# Colston Budd Rogers & Kafes Pty Ltd

20 July, 2022

**RE: STAGE 3 (DFO) EASTERN CREEK QUARTER**  
**UPDATED TRAFFIC MODELLING TECHNICAL NOTE -**  
**ROOTY HILL ROAD SOUTH – CHURCH STREET – ST AGNES AVENUE**

INTERSECTION LAYOUT - CONCEPT LINEMARKING PLAN

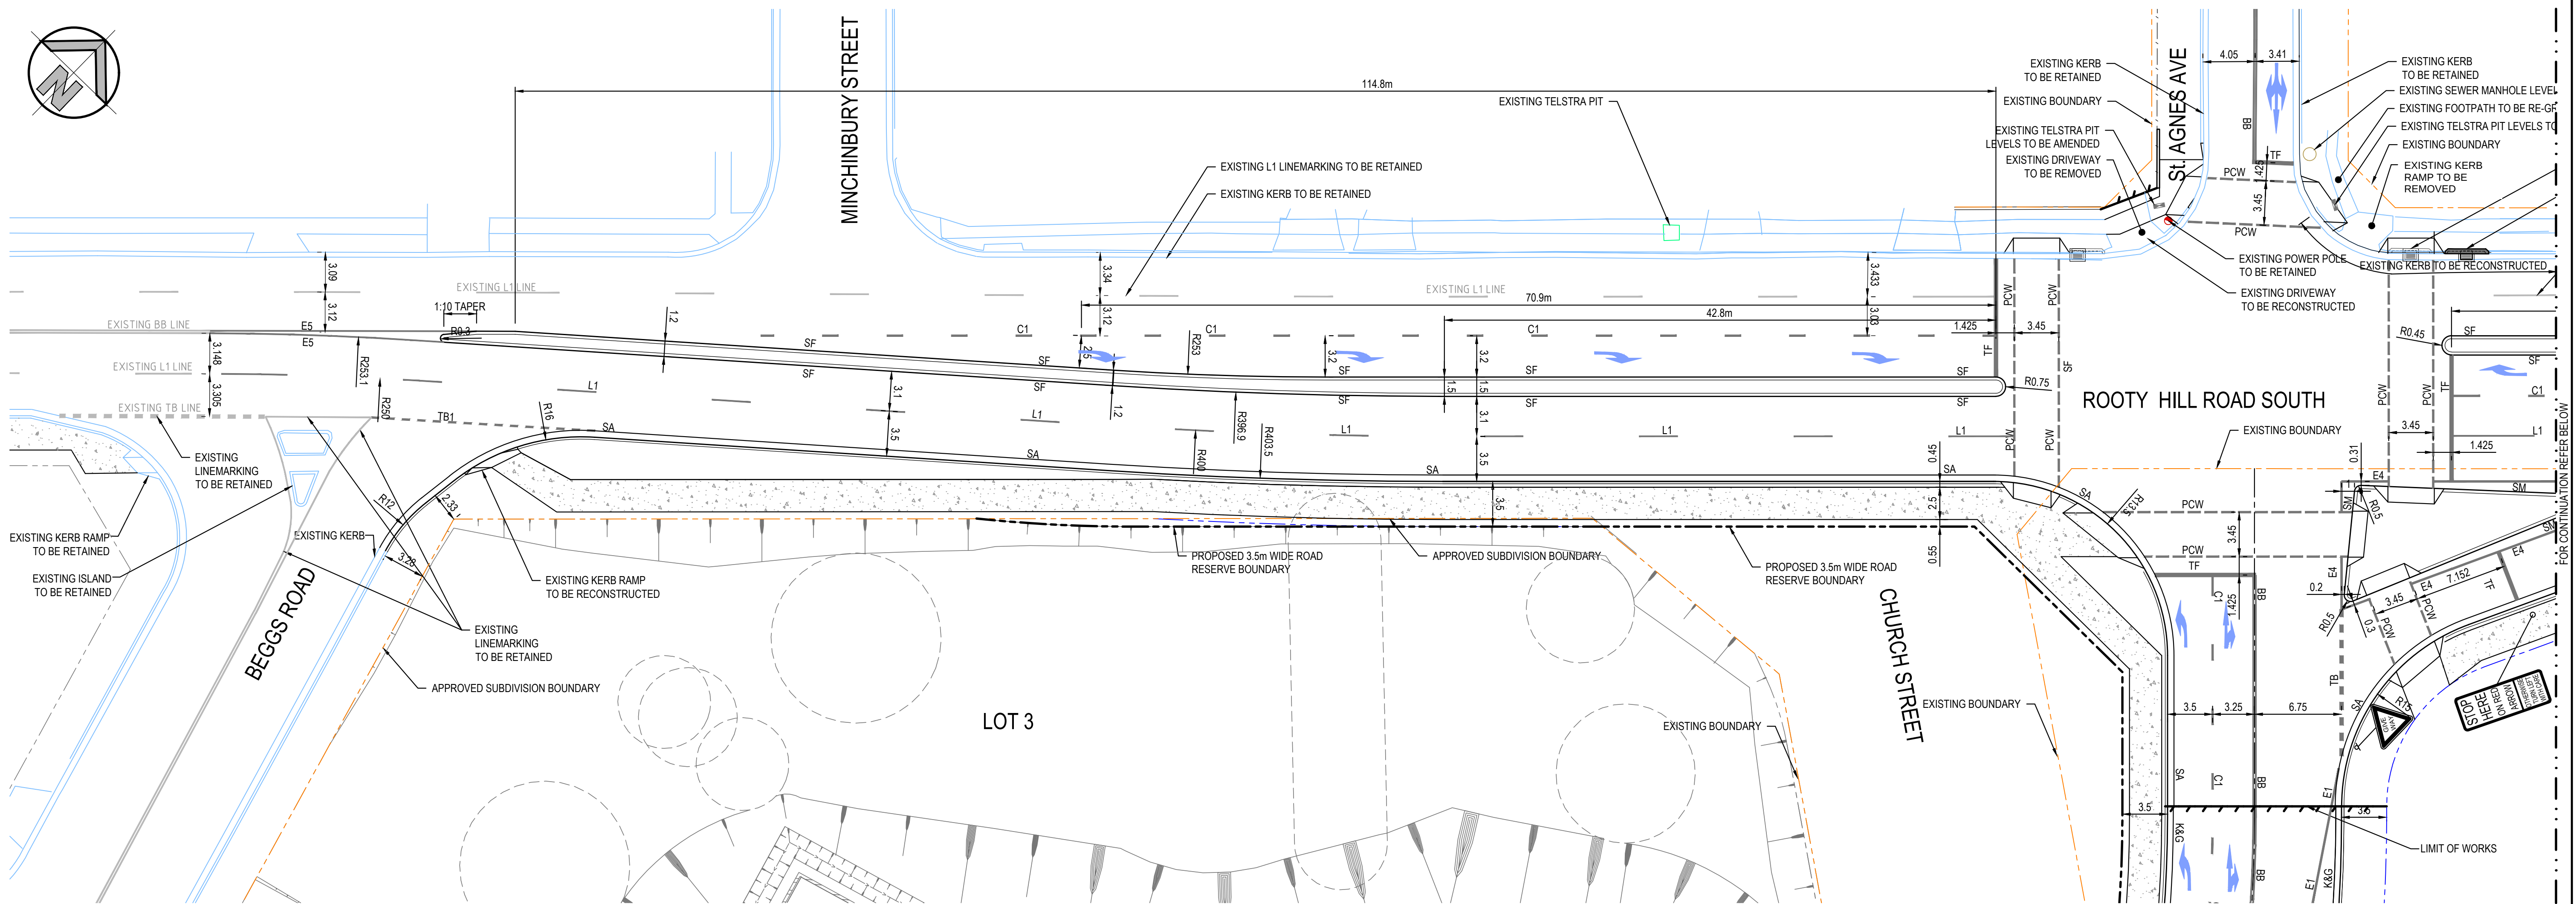
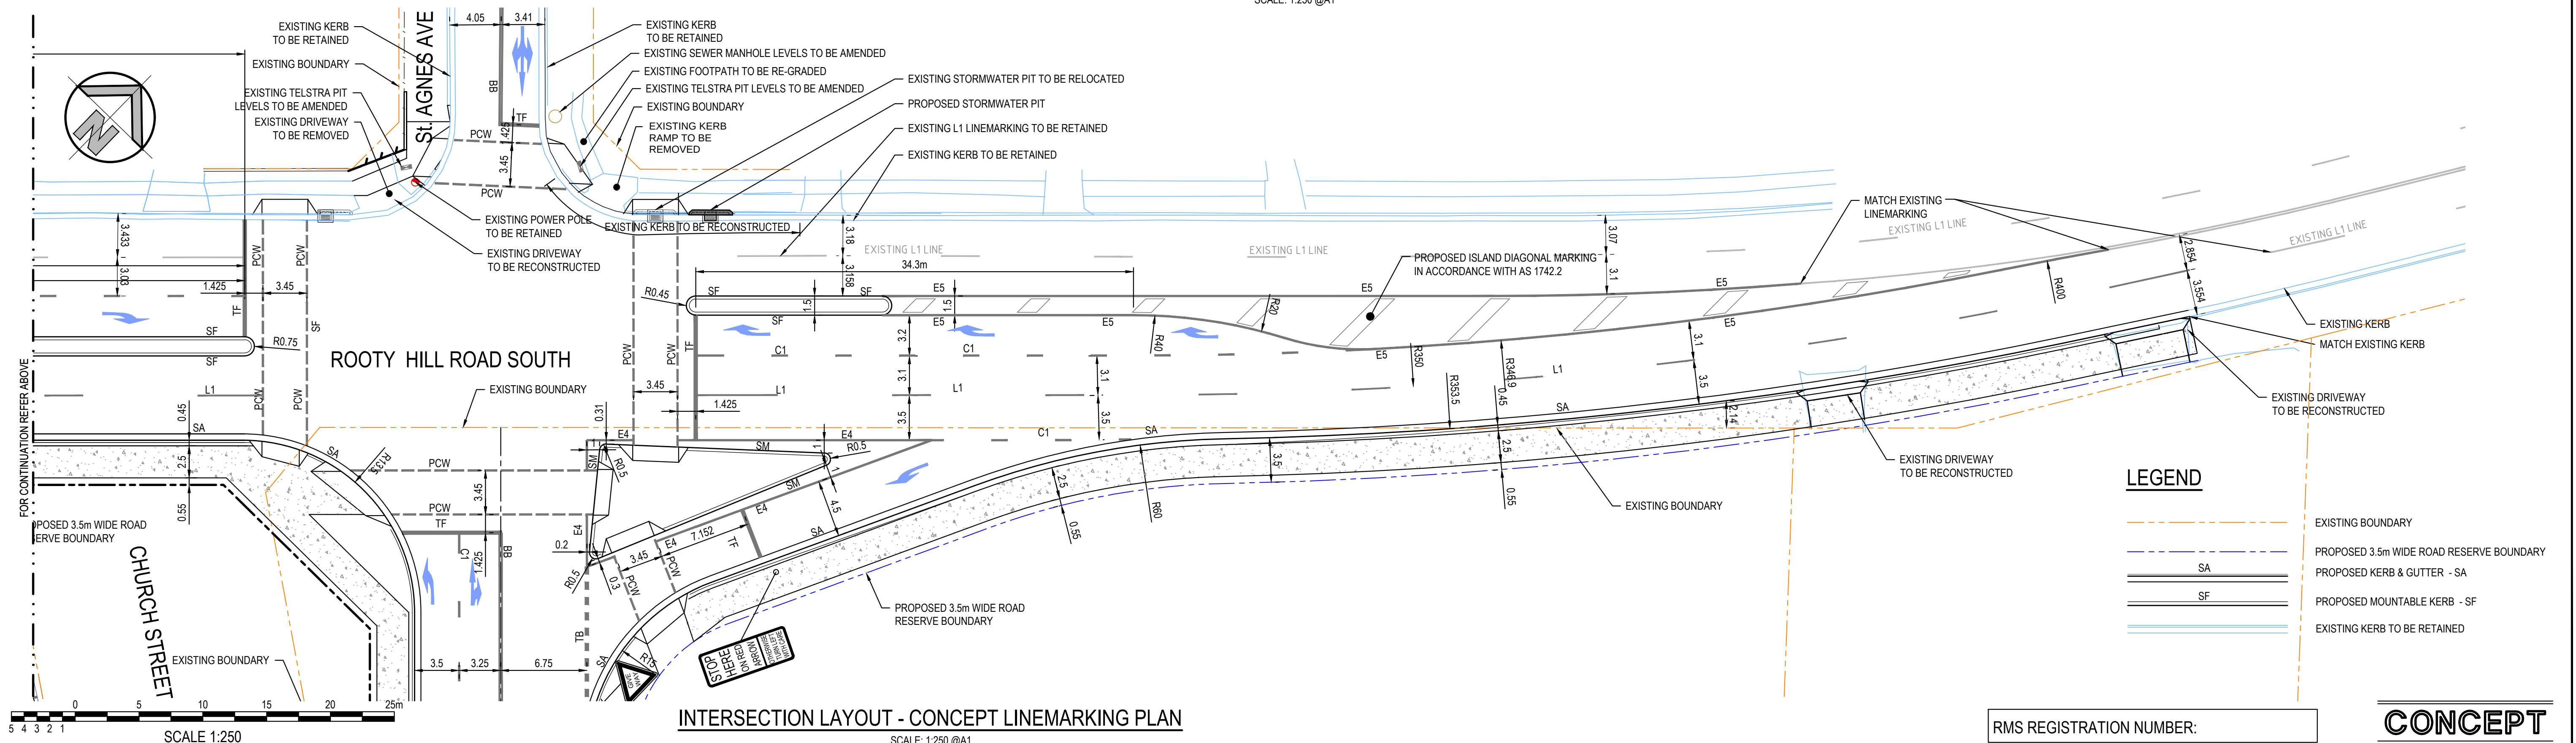
- 1) *The pedestrian crossing on the northern leg is to be located closer to Church Street. As a result the existing drainage pit at the northwest corner will require relocation.*

- 2) *It is understood that a kerb ramp exists at the northwest corner which is used as a driveway by the resident. Once the marked crossing is installed, this kerb ramp should be removed and reinstated to match existing kerb and gutter.*

- 6) *TfNSW notes that there is an existing driveway at the southwest conner of St Agnes Avenue. On safety grounds, the driveway should be relocated to St Agnes Avenue, providing a safer access to the resident also in addition to other road users. Please note, it is the responsibility of applicant to obtain written agreement from the landowner, permitting the relocation and any works required by the applicant.*

- Right turn bay into Church Street of 65 metres
- St Agnes Avenue remains as one traffic lane in each direction at the intersection;
- Church Street provides one traffic lane eastbound and two traffic lanes westbound at the intersection (designated left turn lane and shared through and right turn lane); and
- Signalised pedestrian crossings on the all legs of the intersection.
